Ship & Anchor Marina, Station Road, Ford, Arundel BN18 0BJ

9 September 2019

Planning Application F/9/19/PL

To change the use of half the site area to a hard standing storage area (at Station Road, Ford)

Figure 3 Environment Agency's Flood Map

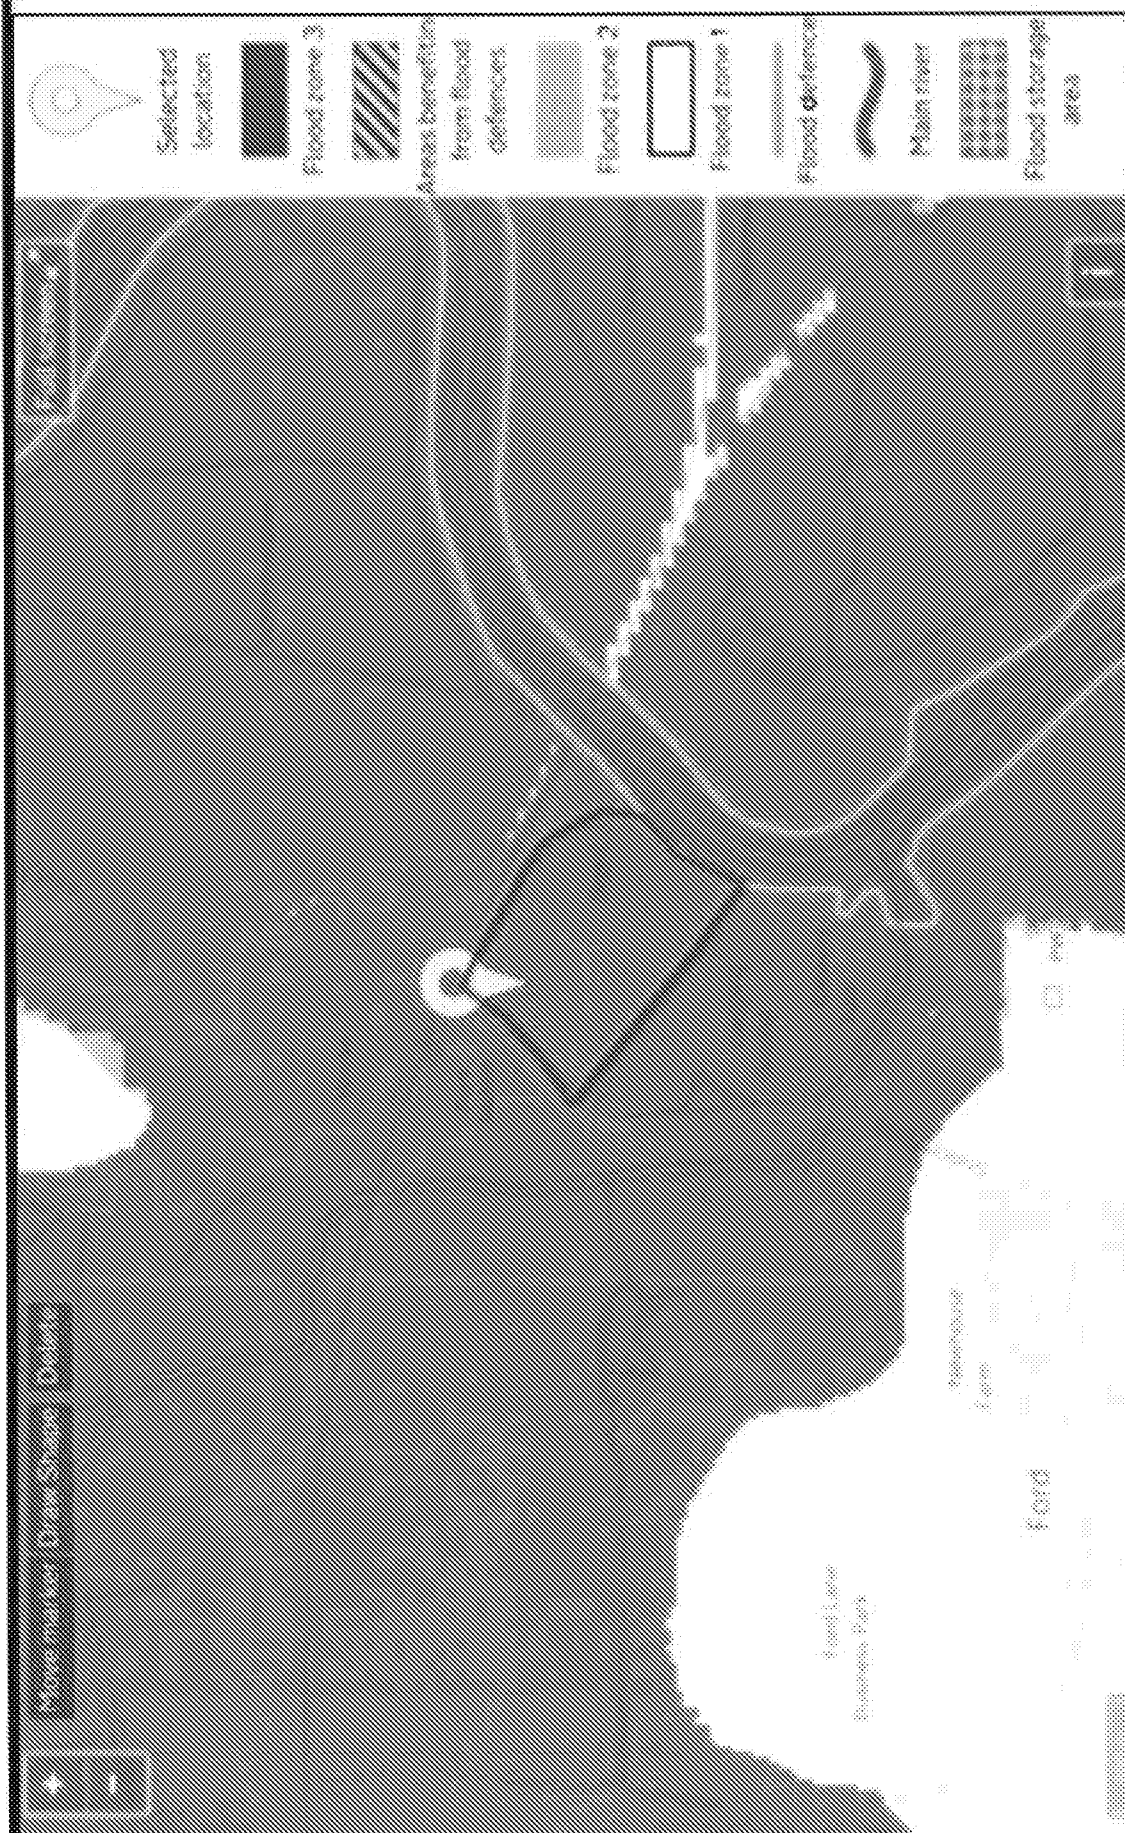
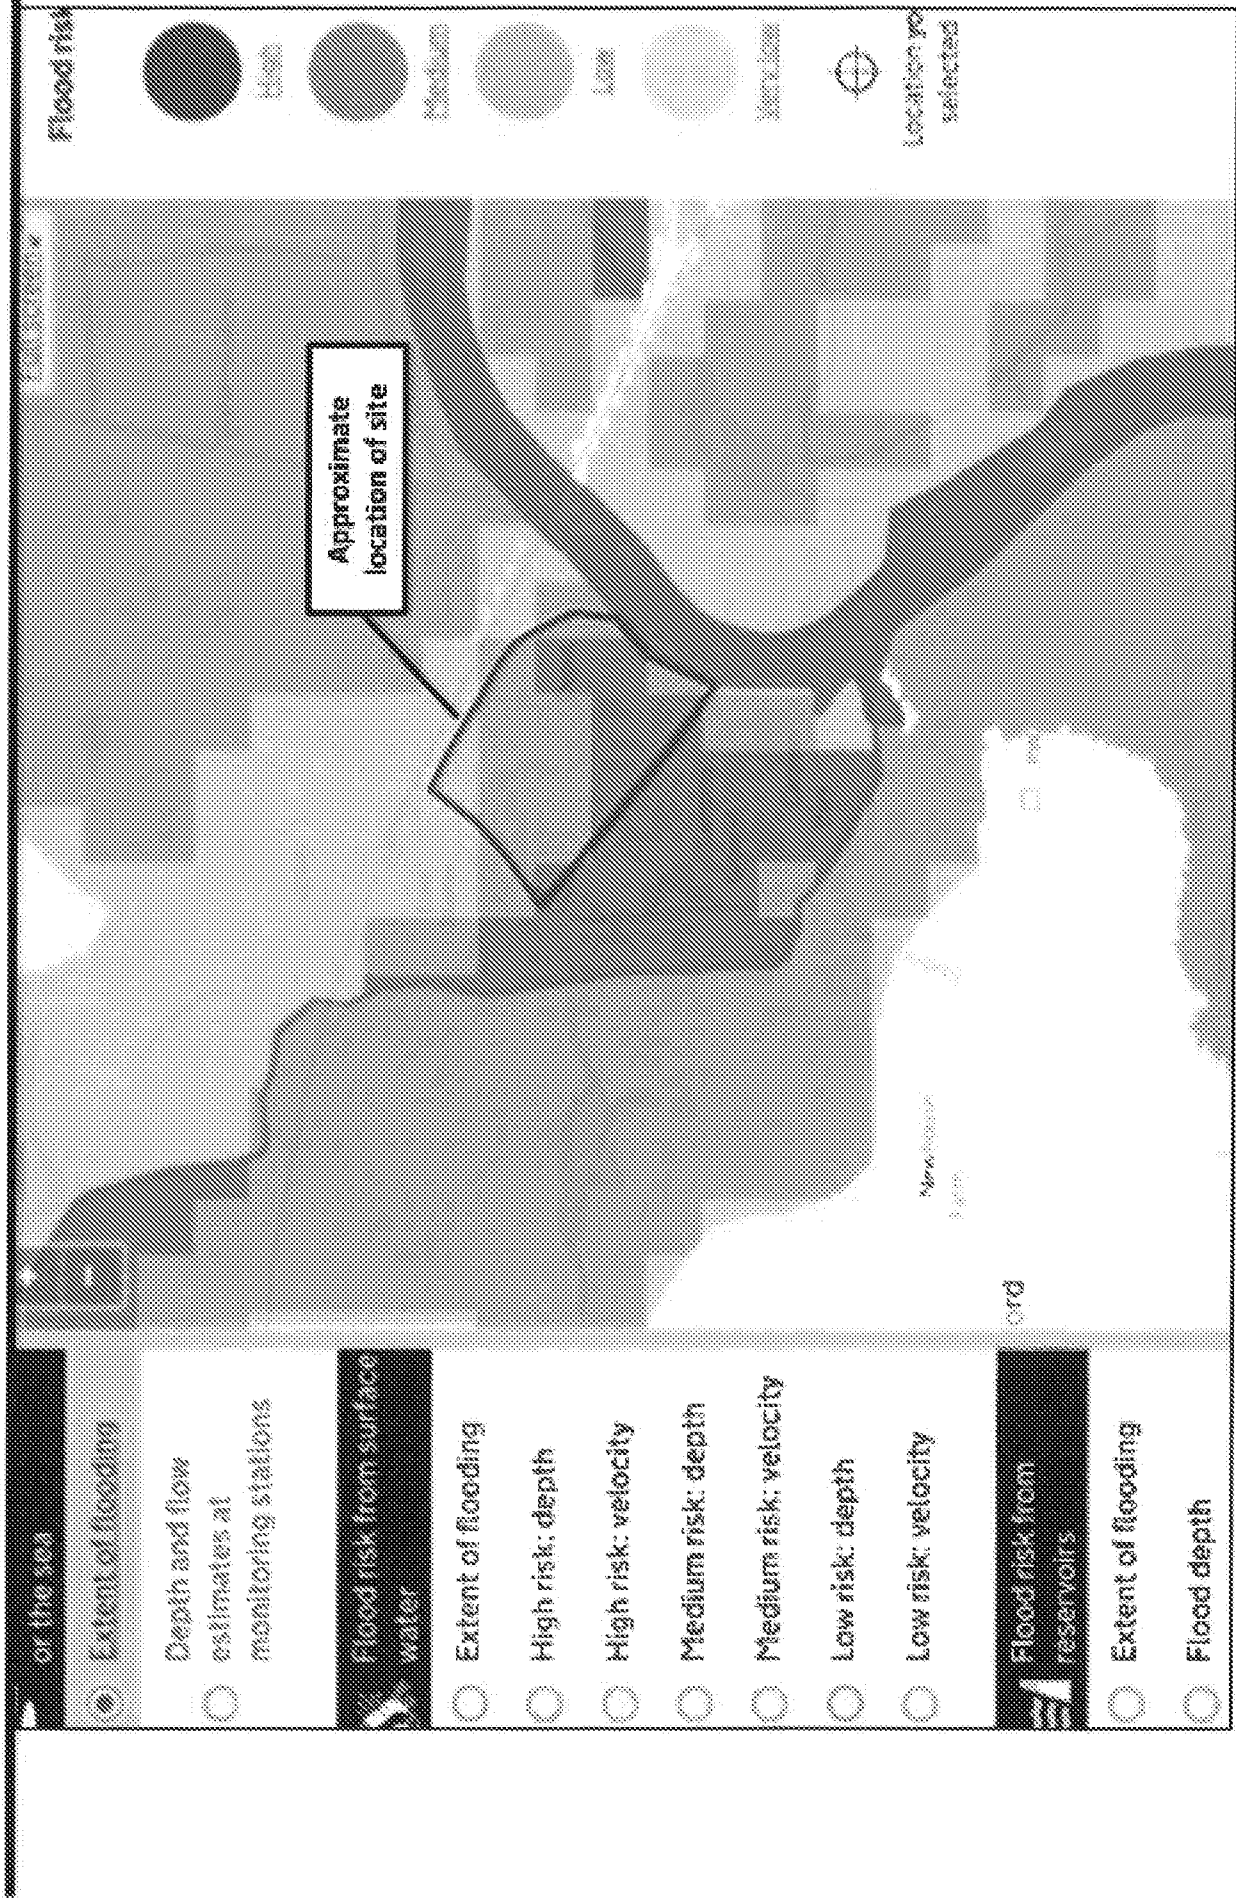
We will not dwell on possible typing errors but the comment under paragraph 1 of our section of the letter that BCS Ltd will *"be working with the Environment Agency to ensure that (the) development would have a negative impact on ... adjoining properties"* is exactly what we believe will be the outcome. There will be an increased risk of flooding if this application is approved. The hard standing is now proposed to be constructed of a permeable surface material (details to be agreed). However, everything being stored and resting on this surface will make the contact areas impermeable.

Under paragraph 2 of our section of the letter, we stand by our original comment and believe from our daily observations that the response (from Brighton) is underestimating the extent of wetness across the field for much of the year.

Proposed entrance and hard standing alteration with change of use

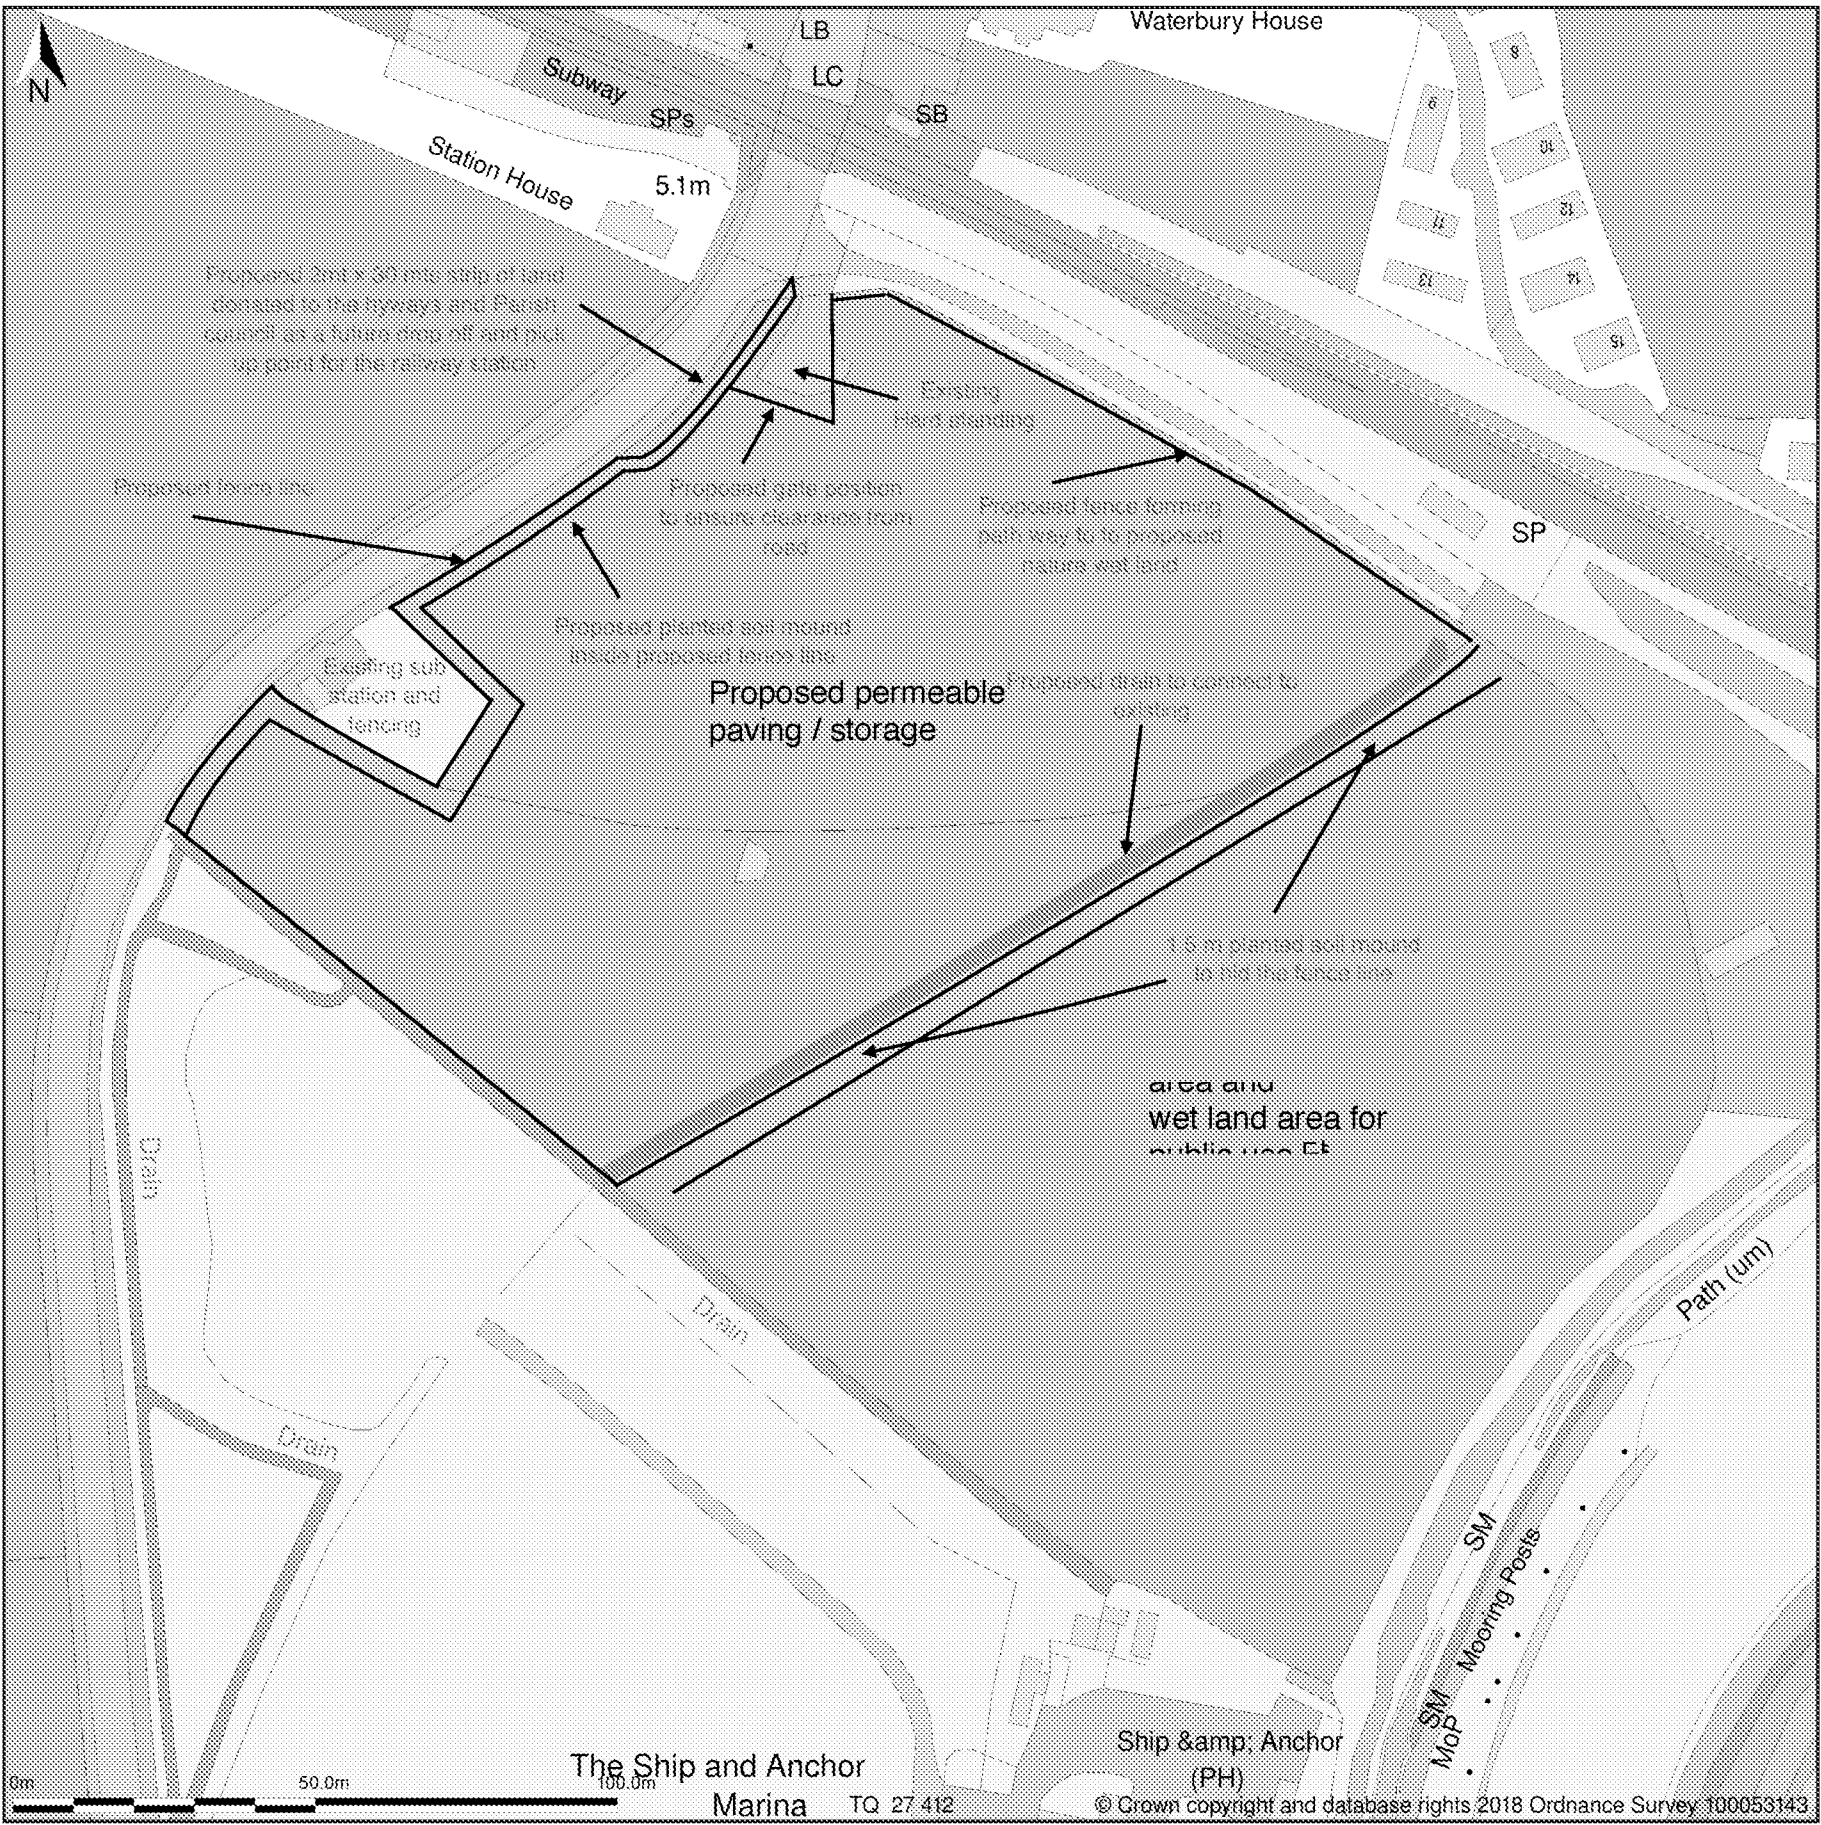
The first sentence of the next paragraph (3) is hard to follow. The plans submitted for the development show a connection into our ditches and we have explained why this cannot occur. To avoid crossing our land, there seem to be only two alternatives: to go directly into the River Arun,

which must be a major and costly undertaking; or to go under the highway and across the land south of Ford Railway Station, but this land also suffers periodically from severe flooding.
